WEST SUSSEX COUNTY COUNCIL CONSULTATION

TO:	Arun District Council FAO: Anita Gardner
FROM:	WSCC - Highways Authority
DATE:	17 November 2020
LOCATION:	57 River Road Littlehampton BN17 5DD
SUBJECT:	LU/247/20/PL Partial demolition of existing building, retention of boundary wall & street facade, partial demolition of boundary wall to incorporate new pedestrian gateway & gate, erection of 6 No. flats in 2 blocks connected by shared stair & lift core, on site parking yard for 8 No. cars & 8 No. cycles & space for communal refuse & recycling bins. This application affects the character & appearance of the Littlehampton River Road Conservation Area & is in CIL Zone 4 (Zero Rated) as flats. Awaited trip assessment figures received.
DATE OF SITE VISIT:	n/a
RECOMMENDATION:	Advice
S106 CONTRIBUTION TOTAL:	n/a

DRAWING NO: 1908_P_200 **REVISION 02**

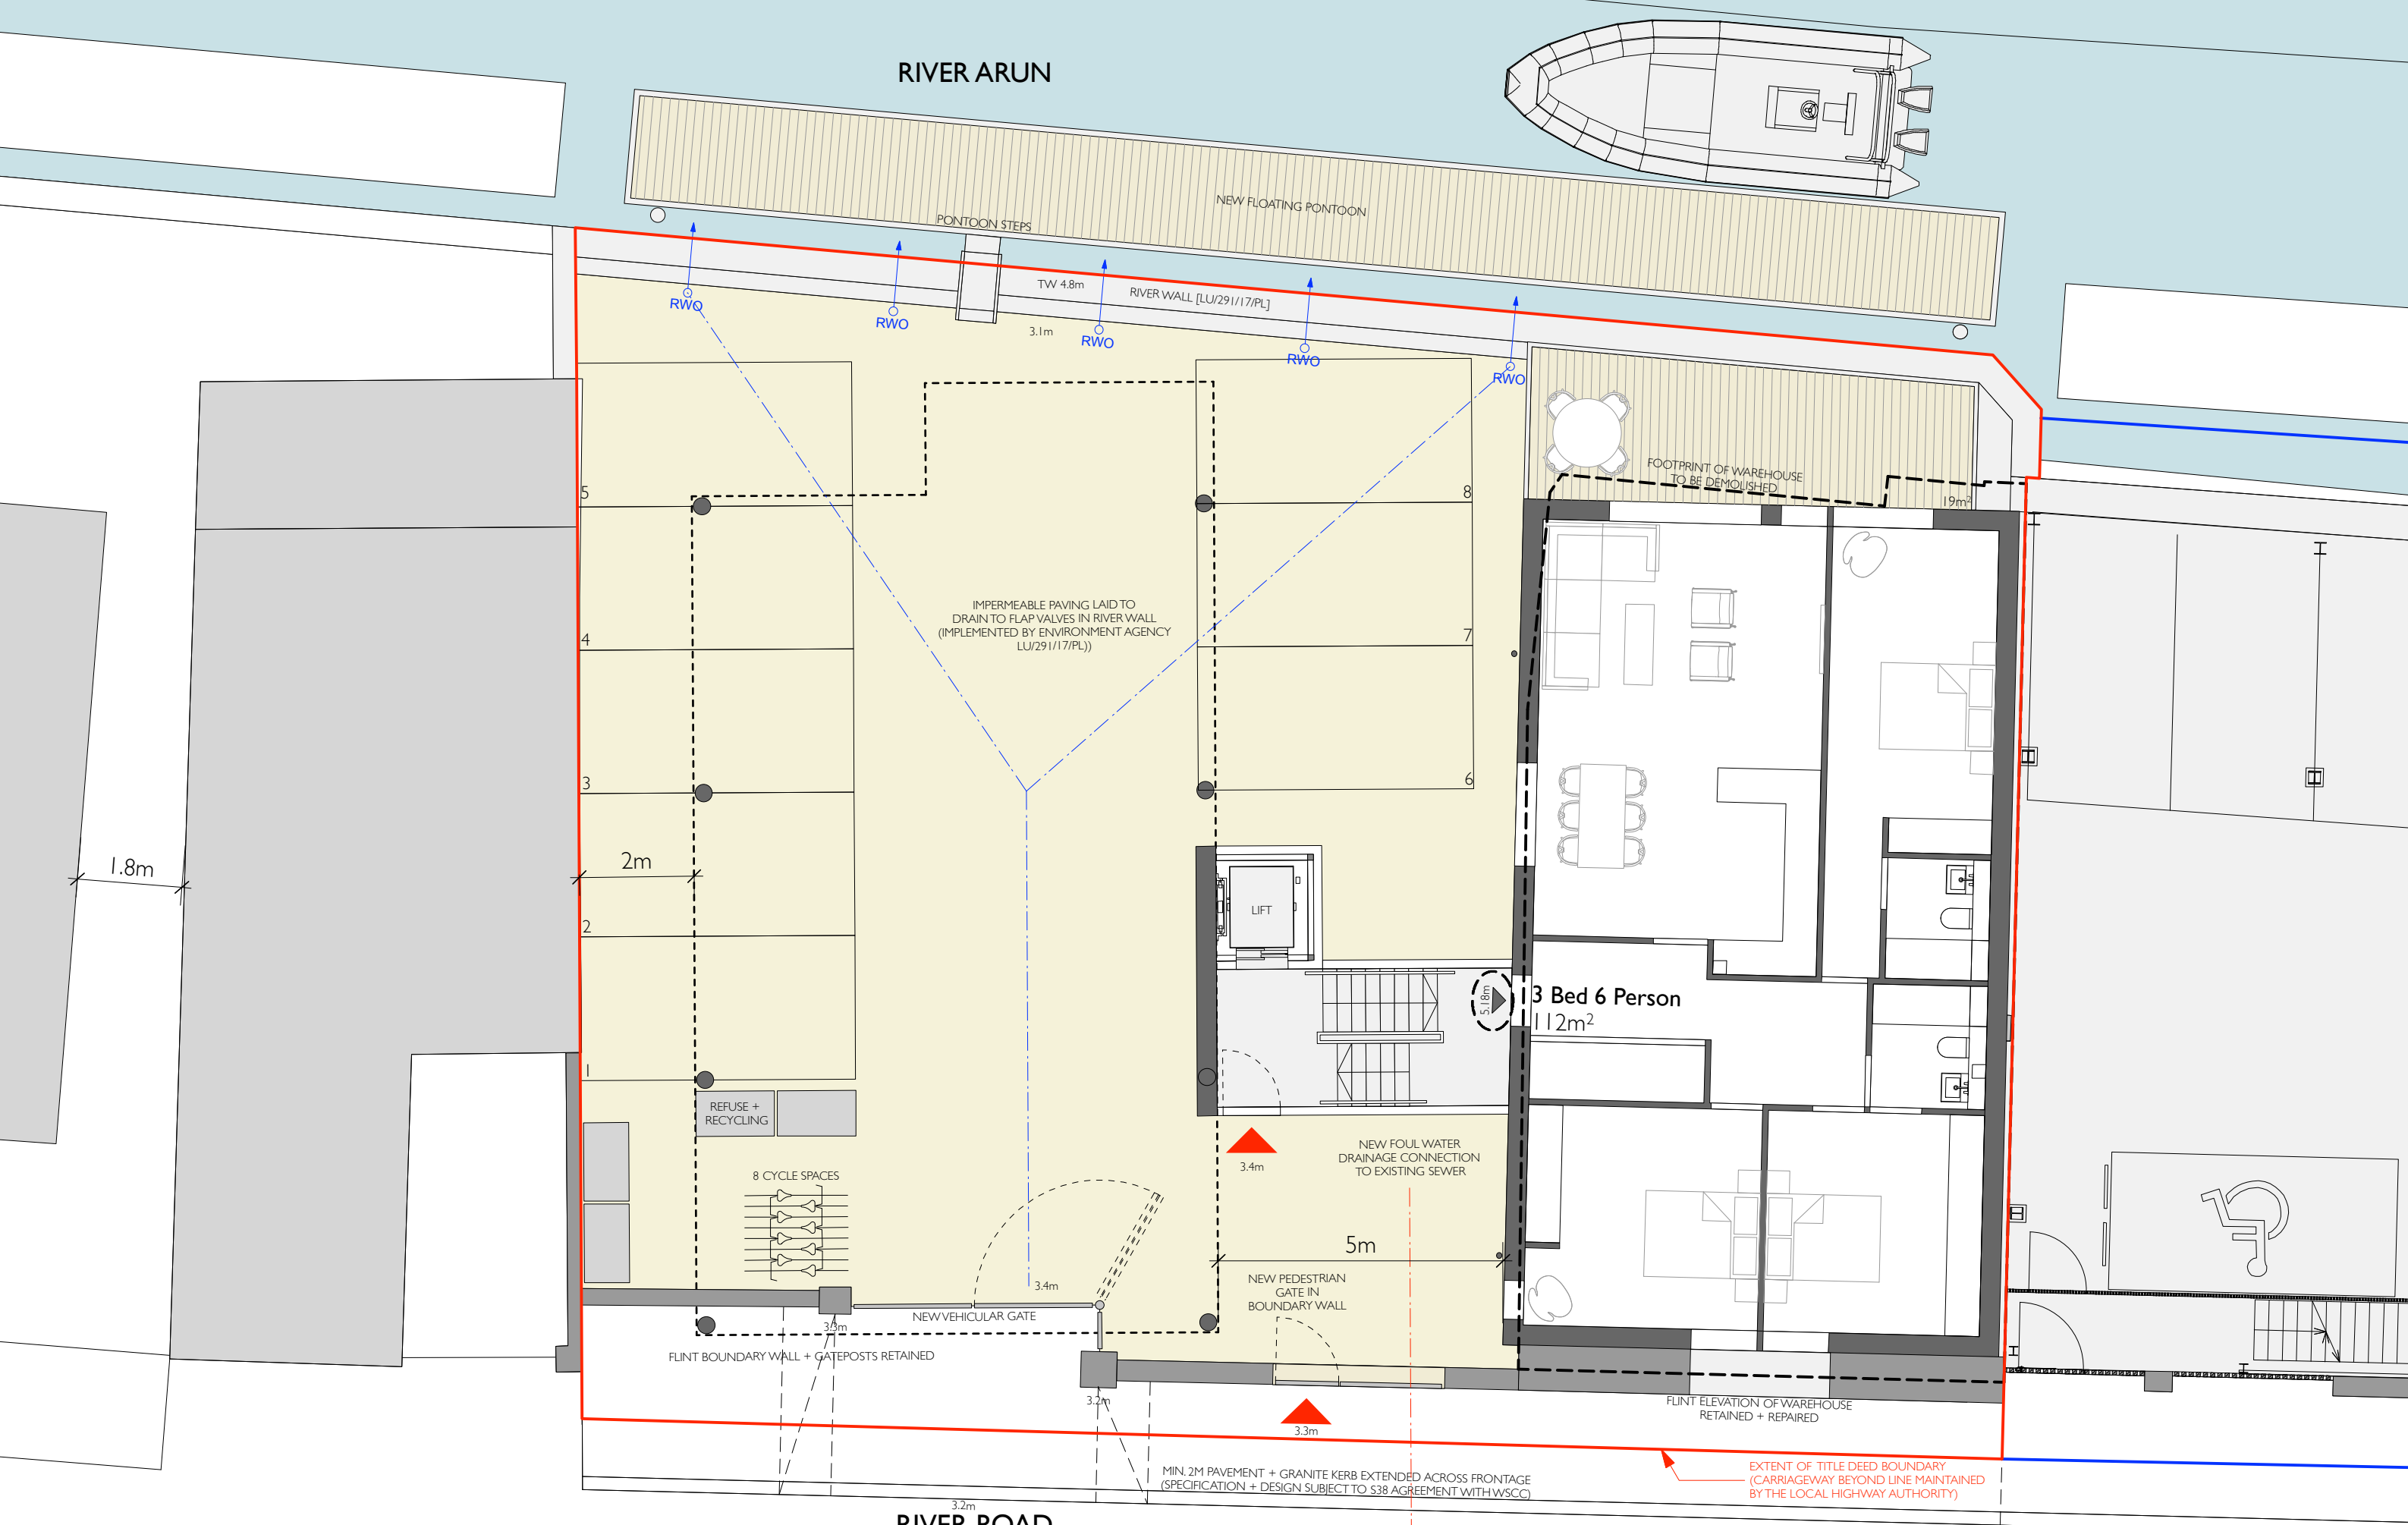
The applicant proposes a 2m minimum width footway across the entire frontage of the site, including a 4.5m wide dropped kerb for vehicular access. These works would be subject to Section 278 and 38 agreements - the applicant is advised to enter into early discussions with WSCC regarding the proposed works.

The proposed vehicular gates will open inwards of the site so as not to obstruct the highway. Ideally the gates would be positioned a minimum of 5m back from the back edge of the carriageway to allow a vehicles to wait clear of the highway whilst the gates are in operation. However given that the existing gates are currently located in the same position and that the proposed footway and dropped kerb will increase the distance of the gates from the back edge of

the carriageway, the LHA would not raise any objections to the proposed gate positioning in this location.

The proposed parking area will provide parking for 8 vehicles. It is assumed that this provision will remain unallocated for the development. Based upon the proposal for 4 x 3-bed flats and 2 x 2-bed flats, the WSCC car parking demand calculator would expect that 10 parking spaces are required for a development of this size and location, to include visitor provision. The LHA anticipate that of shortfall of two parking spaces, one of these would likely be visitor provision, therefore, there is a potential shortfall in residents' parking of one space. The applicant is advised to consider whether a 9th parking space could be accommodated on site. The LPA may wish to consider the potential impacts of this development on on-street parking from an amenity point of view. Each parking space meets minimum specifications of 2. x 4.8m as set out in Manual for Streets, and there appears to be sufficient space for vehicles to turn on site and exit in a forward gear.

The site is sustainably located within walking distance to a variety of shops and services within Littlehampton town centre. Cycling is a viable option within the vicinity and 8 cycle spaces are provided on site for the residents, to encourage sustainable transport methods. Ideally these spaces should be covered to protect them from adverse weather. Details of this can be secured via condition.

No part of the development shall be first occupied until such time as the vehicular access serving the development has been constructed in accordance with the details shown on the drawing titled Proposed Ground Floor Plan and numbered 1908 P 200 Rev 2.
